Wylfa Newydd Project

Horizon's Response to Other Matters Raised by Stakeholders at Deadline 9

PINS Reference Number: EN010007

17 April 2019

Scale	AS SHOWN	Sheet Size	A1	Sheet(s)	1 of 1
Drawing Number	WN0902-HZDCO-OHW-DRG-00063				Rev
				2.0

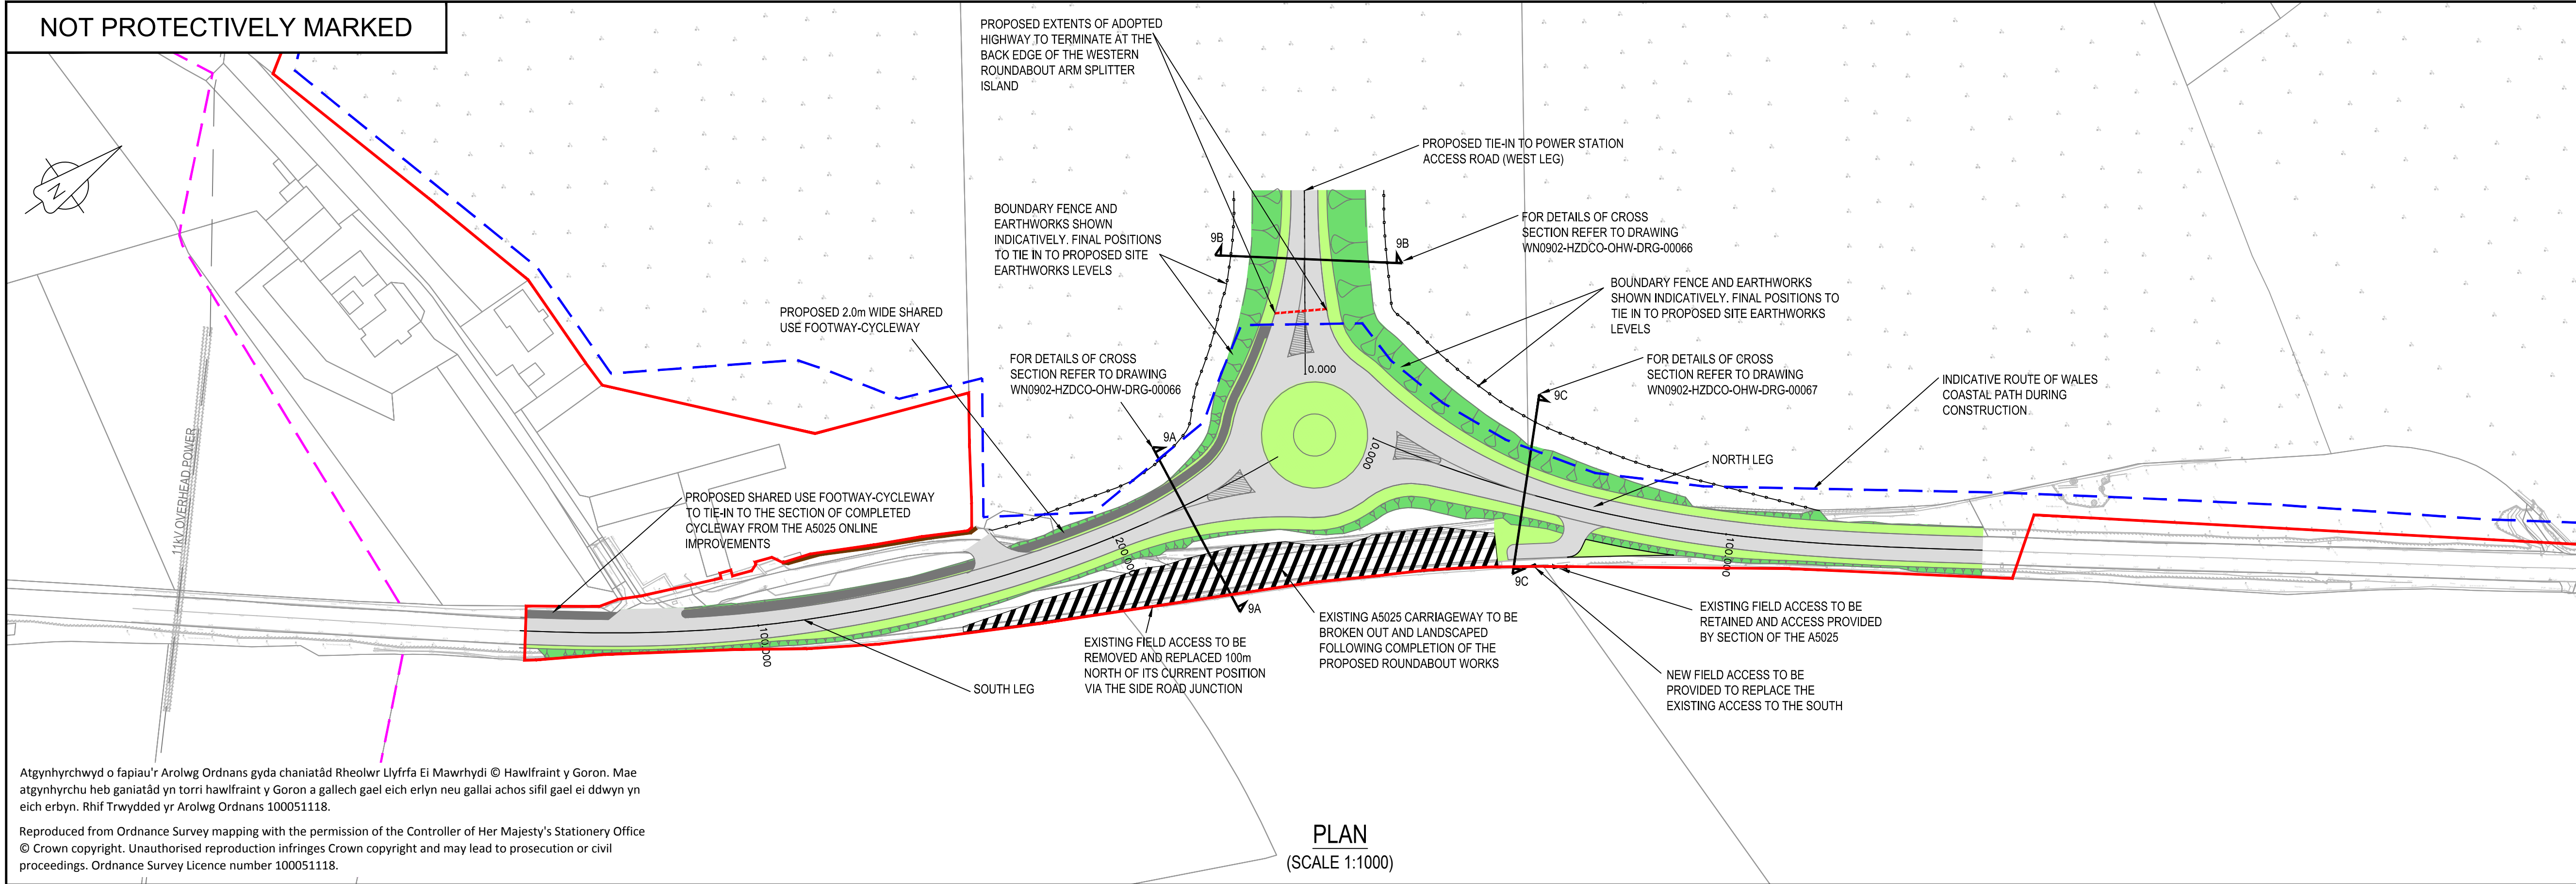
Interested Party	Reference [REP, Section, Para]	Horizon's Response
IACC	Section 8: WNDA Access Junction [REP9-031]	<p>Horizon does not agree with the IACC suggestion that provision of a new turning area in the layby adjacent to the WNDA access junction is required.</p> <p>As shown in the section 9 WNDA access junction plan WN0902-HZDCO-OHW-DRG-00063 [APP-015] the existing layby will be retained. On this basis Horizon will not be implementing any amendments to the corresponding DCO plans.</p>
NDA	[REP9-040] – Article 29 (Private Rights) p.6	<p>Horizon's response remains as set out in paragraphs 1.2.9 – 1.2.30 of the Outstanding Issues Register [REP8-004] and Horizon has already given effect to NDA's request through article 29(5) and new article 37(3).</p> <p>Paragraph (5) of Article 29 states that "This article does not apply in relation to any right that is a "relevant right" within the meaning of section 138 of the 2008 Act (Extinguishment of rights, and removal of apparatus, of statutory undertakers etc.) or where article 37 (Statutory undertakers) applies." (our emphasis).</p> <p>In the Deadline 8 update to the DCO [REP8-029], Horizon amended article 37 to make it clear that NDA was considered a statutory undertaker for the purposes of that section. Article 37(1)(c) provides that the undertaker's ability to extinguish or suspend rights belonging to statutory undertakers within the Order Limits is subject to the protective provisions in Schedule 15 of the Order. The protective provisions applying to NDA provide that Horizon cannot extinguish or suspend any right of NDA in the NDA unless it has NDA's agreement and unless the designating directions have been modified or revoked and the NSL licence has been revoked or surrendered. These provisions have been agreed with NDA (as confirmed in its Deadline 9 submission [REP9-040]).</p>
